STATE OF NORTH CAROLINA  
DEPARTMENT OF TRANSPORTATION

April 21, 2004

Subject: **Response to USACE Comments for Application for Individual Section 404 and 401 permits** for the US 17 widening from SR 1327/1410 north of Jacksonville to SR 1330/1439 south of Belgrade/Maysville in Onslow County, North Carolina Federal Aid Project No. NHF-17(7) State Project No. 8.T190301, WBS Element 34442.1.1

PROJECT REFERENCE NO. R-2514A	SHEET NO. EC-29/CONST.28
R/W SHEET NO.	
ROADWAY DESIGN ENGINEER	HYDRAULICS ENGINEER
CONST. REV.	
R/W REV.

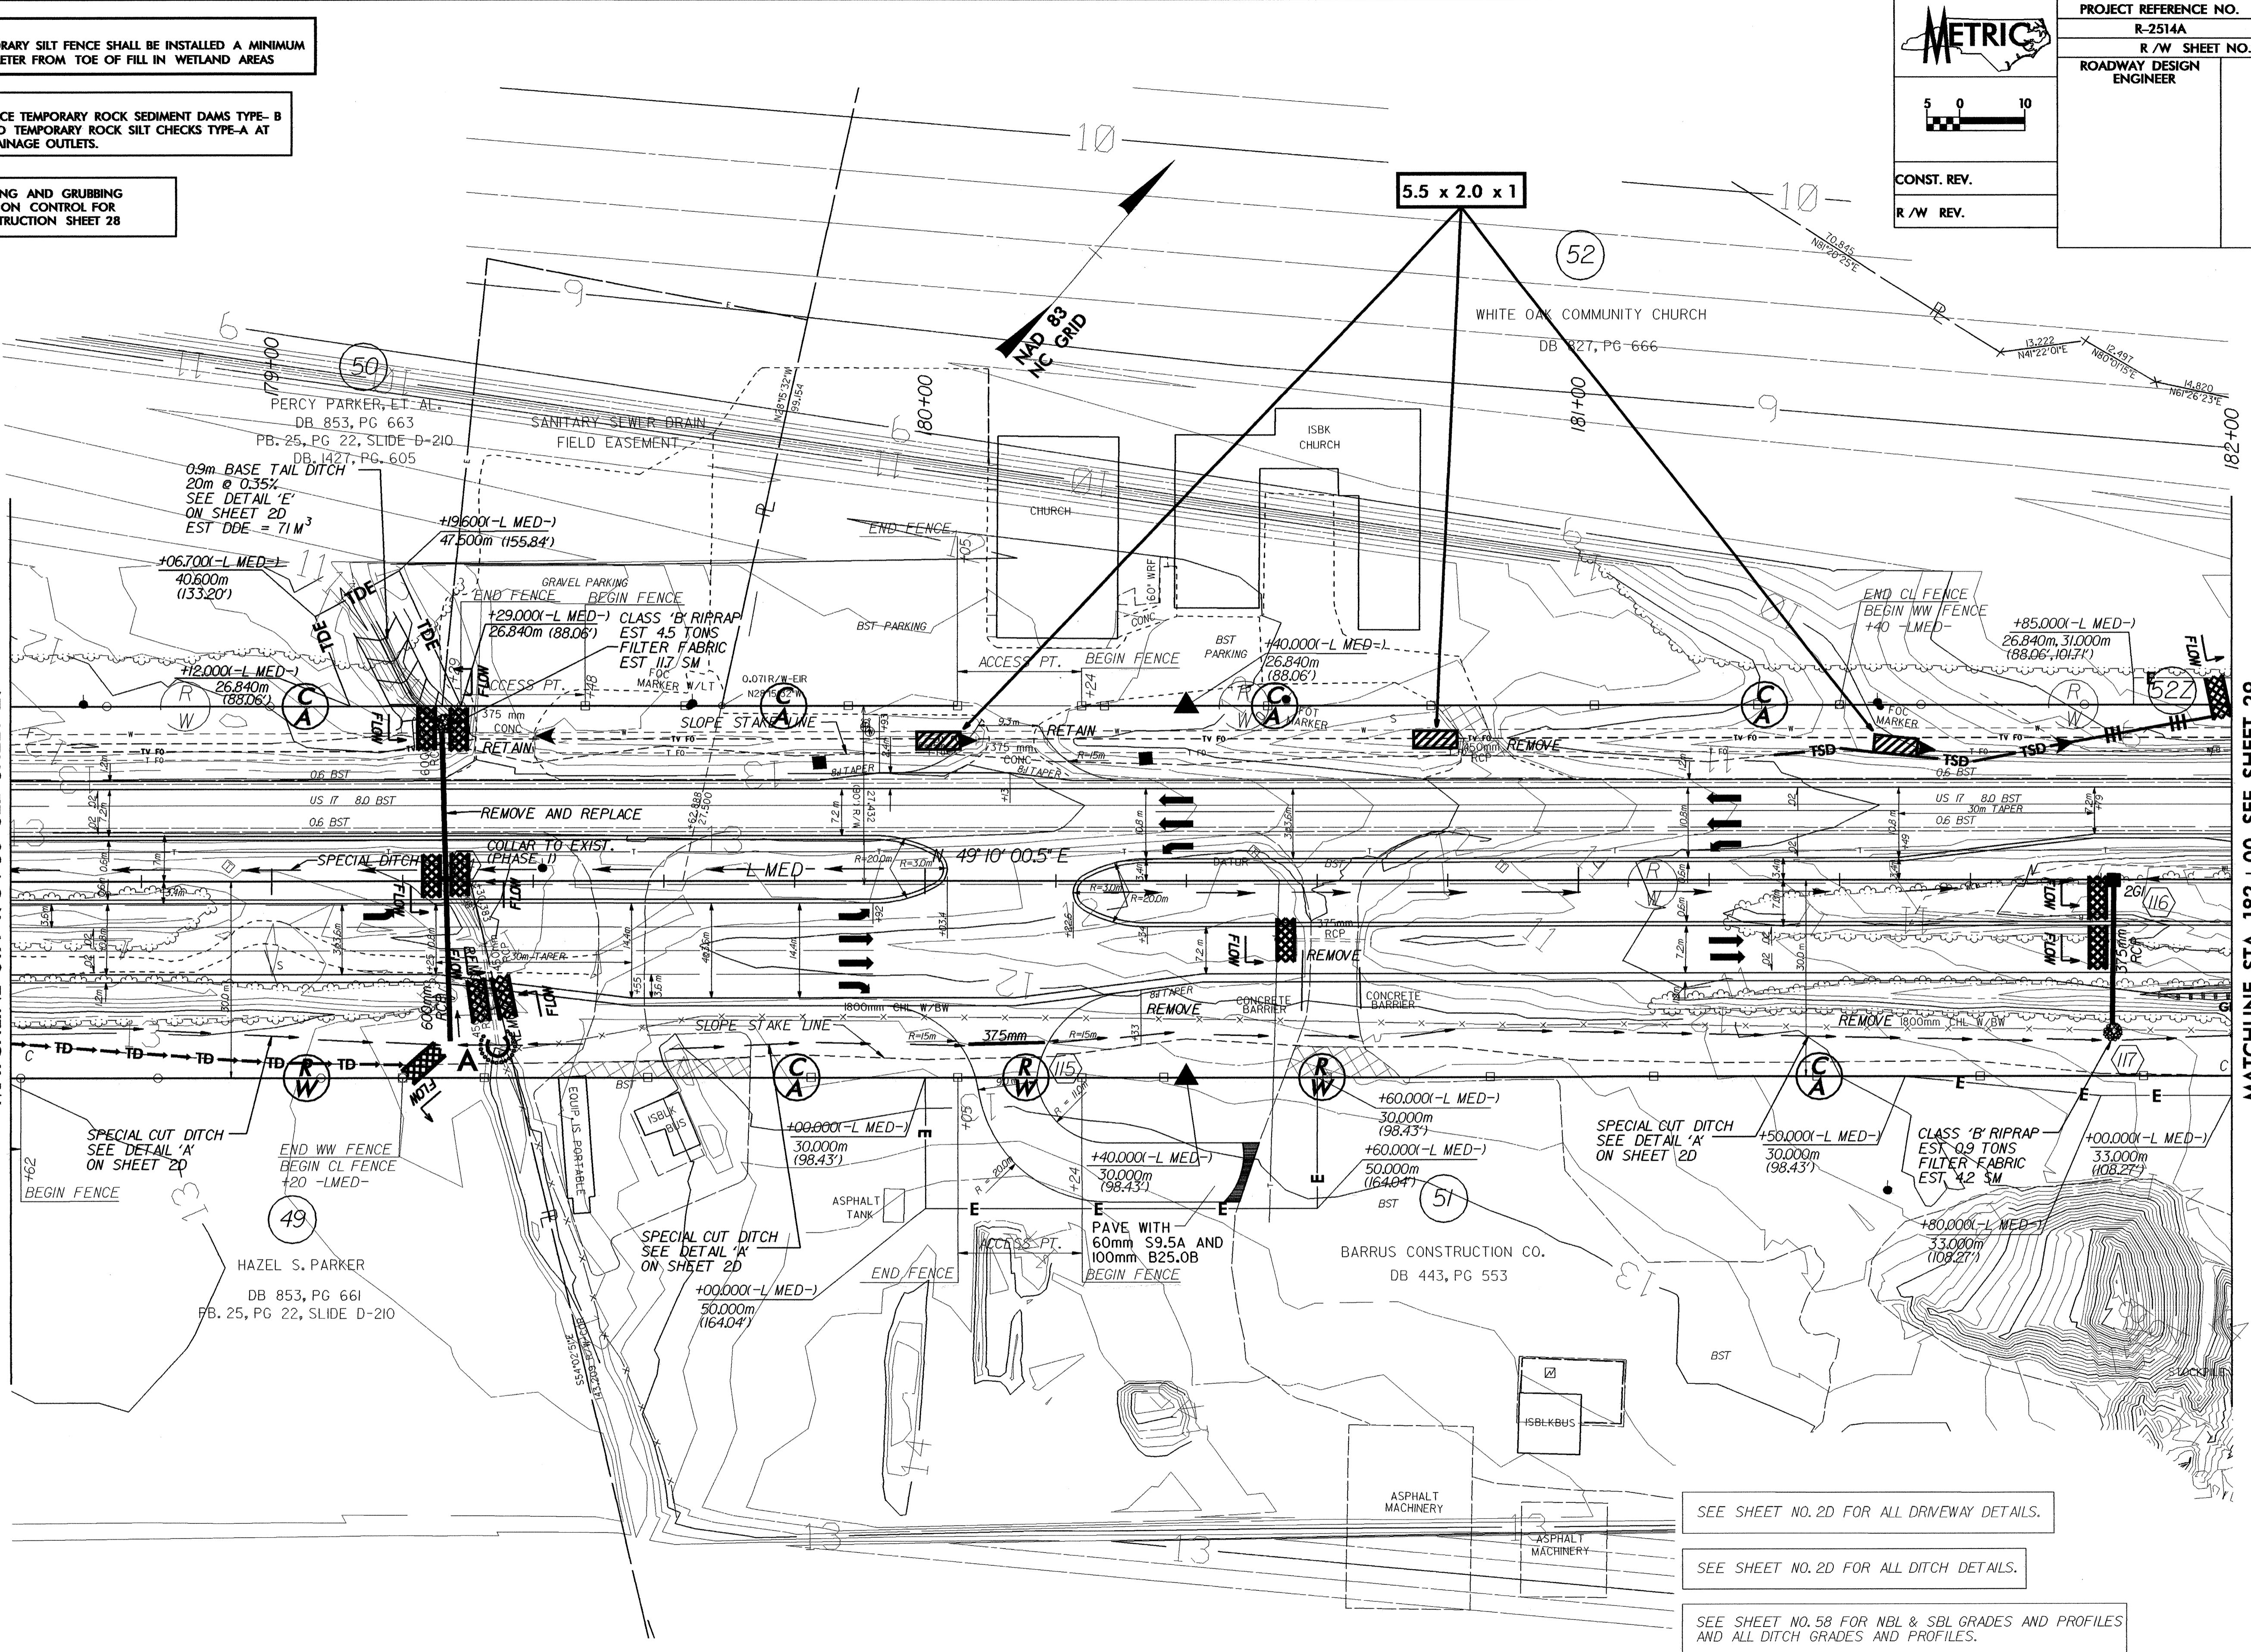
*9. The permit application proposes to replace the existing bridge over Starkys Creek, Wetland Site 55 and 56, with a cored-slab bridge by using top down construction methods and remove the existing bridge by utilizing temporary work pads constructed in wetlands but within the footprint of the proposed permanent impacts. Based on the permit drawings 61-64 dated April 8, 2003, it is not clear if the permanent fill for the temporary work pads and access roads, including all the temporary pipes and box culverts, is needed for removal of the existing bridge. Although we fully support the proposal to use top down construction methods, we feel removal of the existing bridge can be accomplished without incurring permanent wetland impacts (and associated compensatory mitigation) associated with the work pads and access roads. Moreover, as stated on page 10 of the permit application, the Division of Coastal Management letter dated November 25, 1999 prohibits construction staging areas in wetlands as a condition of its consistency determination. Thus, we highly recommend that the proposed work pads and access roads be replaced with a work bridge that will only result in temporary wetland impacts. We also recommend that the NCDOT Division 3 be consulted on the proposed removal and replacement methods for this bridge. Lastly, it is not clear from the information provided how or where the existing US 17 traffic will be detoured during construction. The traffic detour plan should also be provided.*

The traffic will be shifted using cross-overs inside the median. The impact of these cross-overs (Detours) have been shown on the plans since the early stages of the project design and can be seen on sheets 28 and 29 of roadway plans. The construction activity should not interfere with the traffic flow.
